**ADC Planning Consultation
Response from the Historic Buildings Adviser**

Application Number	AB/105/13/L & AB/104/13/
Address	Bevin Bevin & Co Ltd River Road, Arundel, BN18 9DH
Description	Application for Listed Building Consent for redevelopment and conversion of the former Bevin Bevin site to provide 7No. apartments and 6No. houses with associated car parking
Case Officer	Peter Cleveland
Site Visit	6 November 2013

Objection

Drawing
Houses 5-6 & 7
Elevations

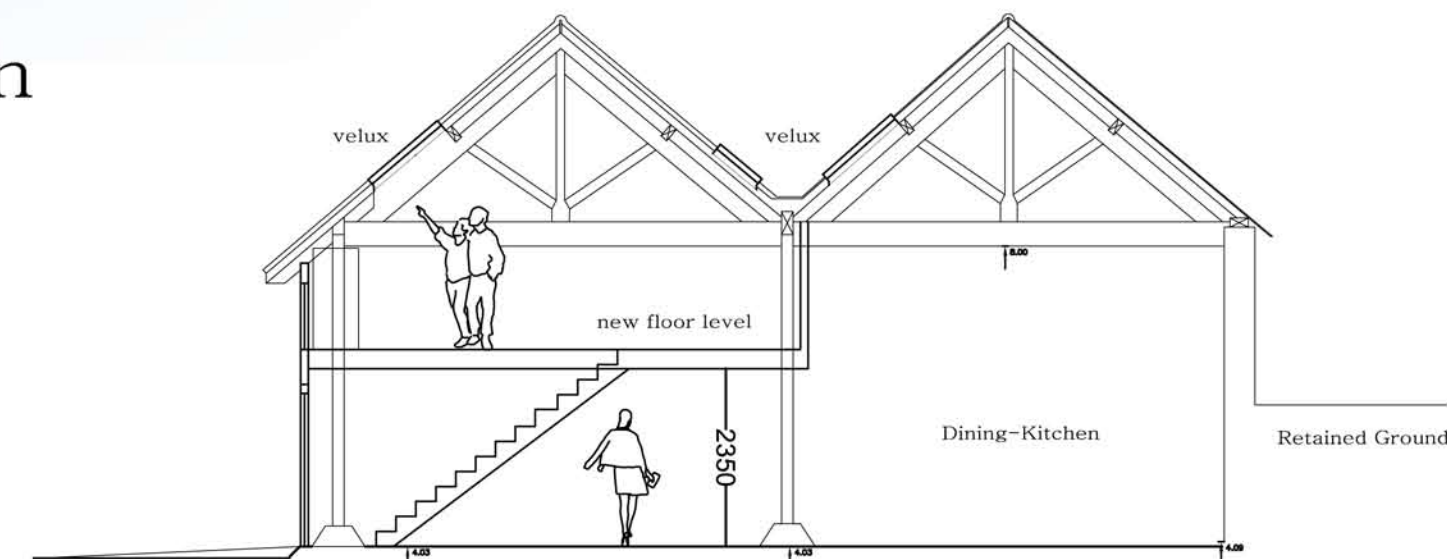
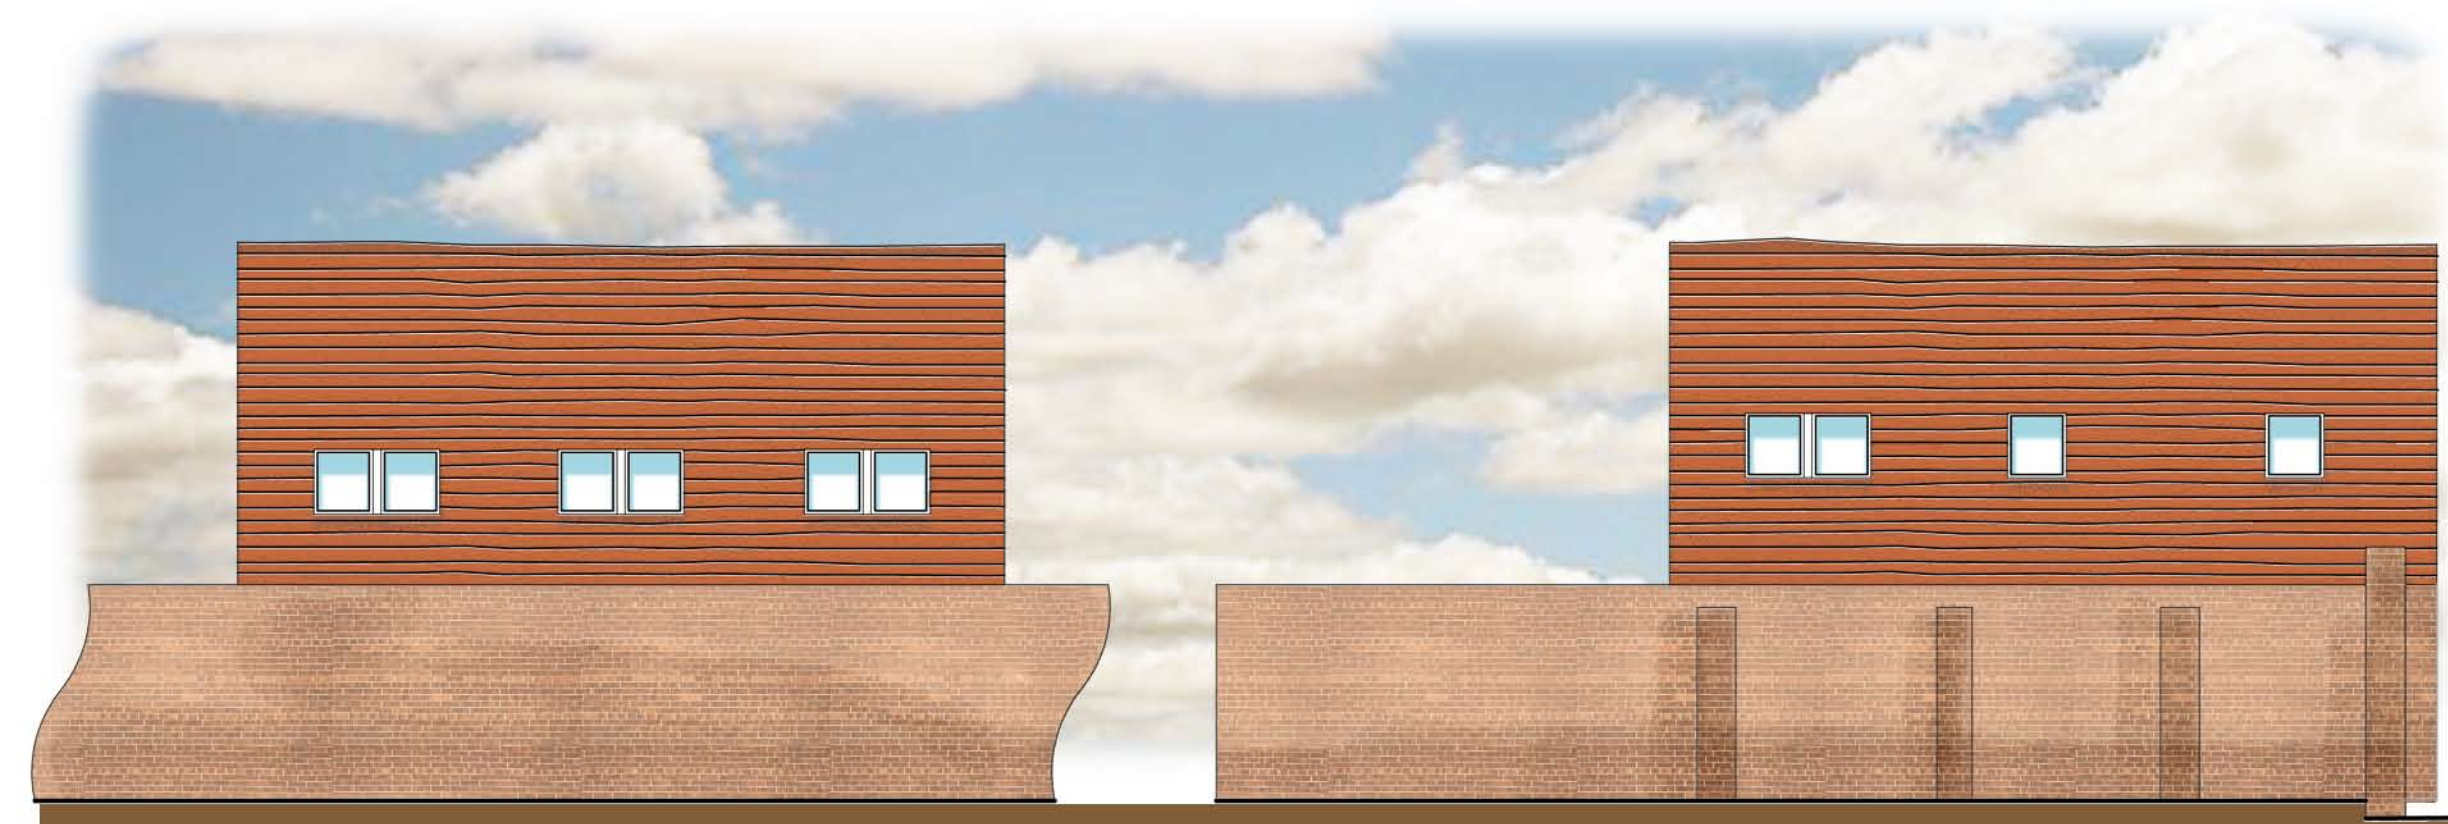
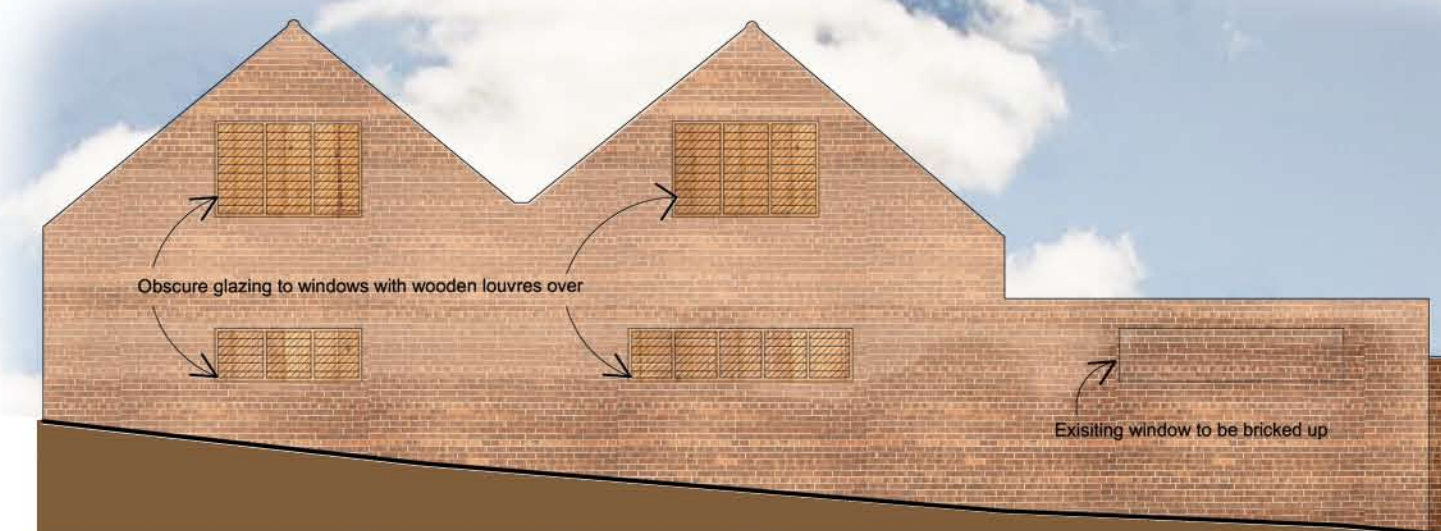
Building 7 is only partially retained, with the roof being removed and the walls left to form a courtyard. This will have consequences for the roof scape of the site and may result in a rather odd courtyard feature in an industrial site. This is not as yet convincing.

Drawing **Houses 10 & 11** Scale:@A3 **1:100**

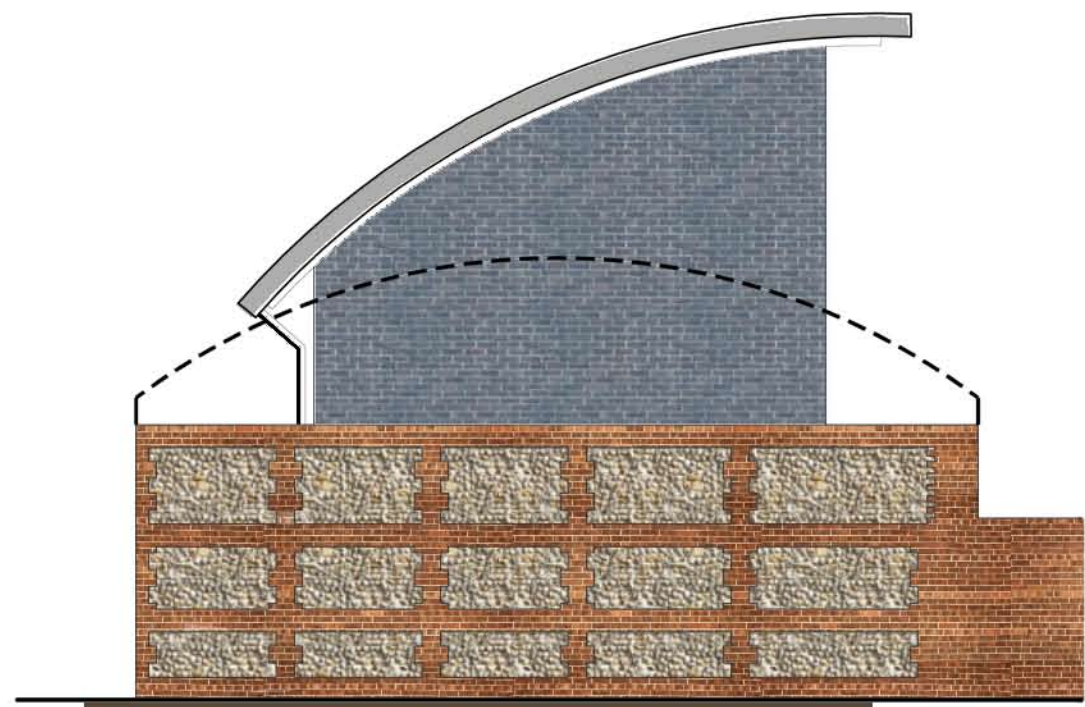
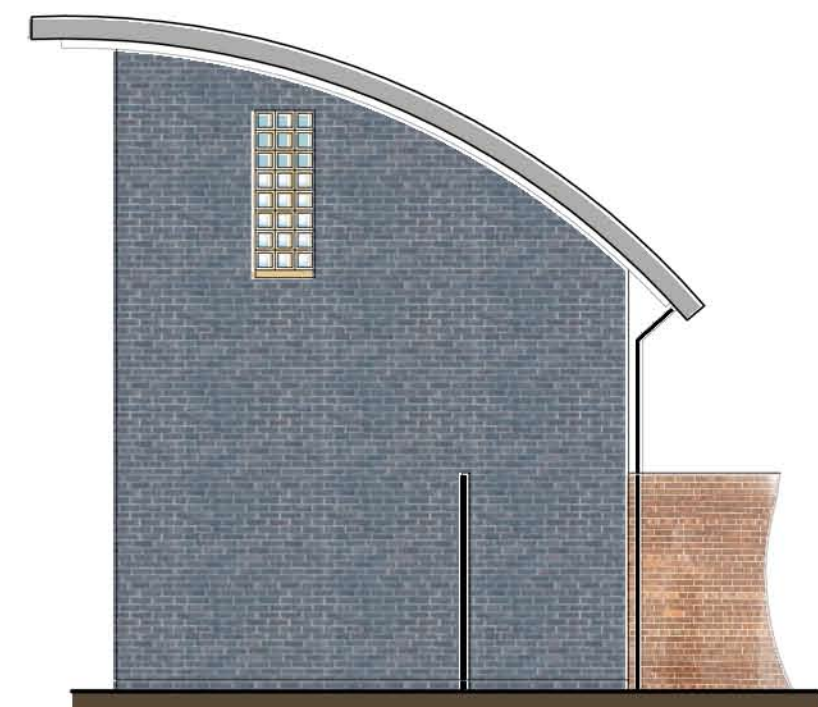
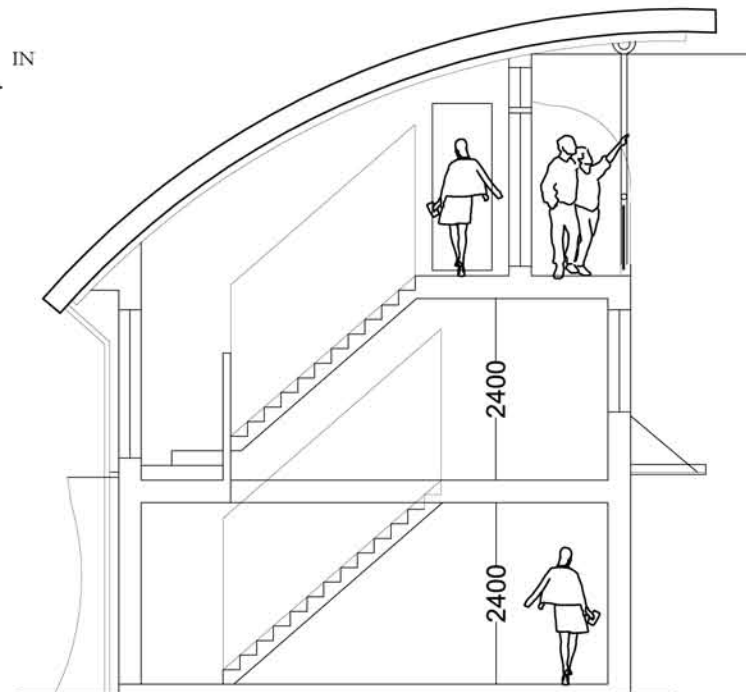
Building 11 is considered to be of low significance, though the main walls are of consequence to this part of the site and the broader street scene. They also appear to have some archaeological value in terms of the fabric and stone types. The proposed dwellings here have sought to maintain an industrial aesthetic with sliding wooden doors etc. Whilst this might work, it may also be achieved purely through the design and proportion of the fenestration allowing

the buildings to appear more understated and less cluttered. At present the proposed scale of the buildings also still appears rather large for their context. I would be interested to see a perspective from the site back towards River Road so their full impact can be properly assessed.
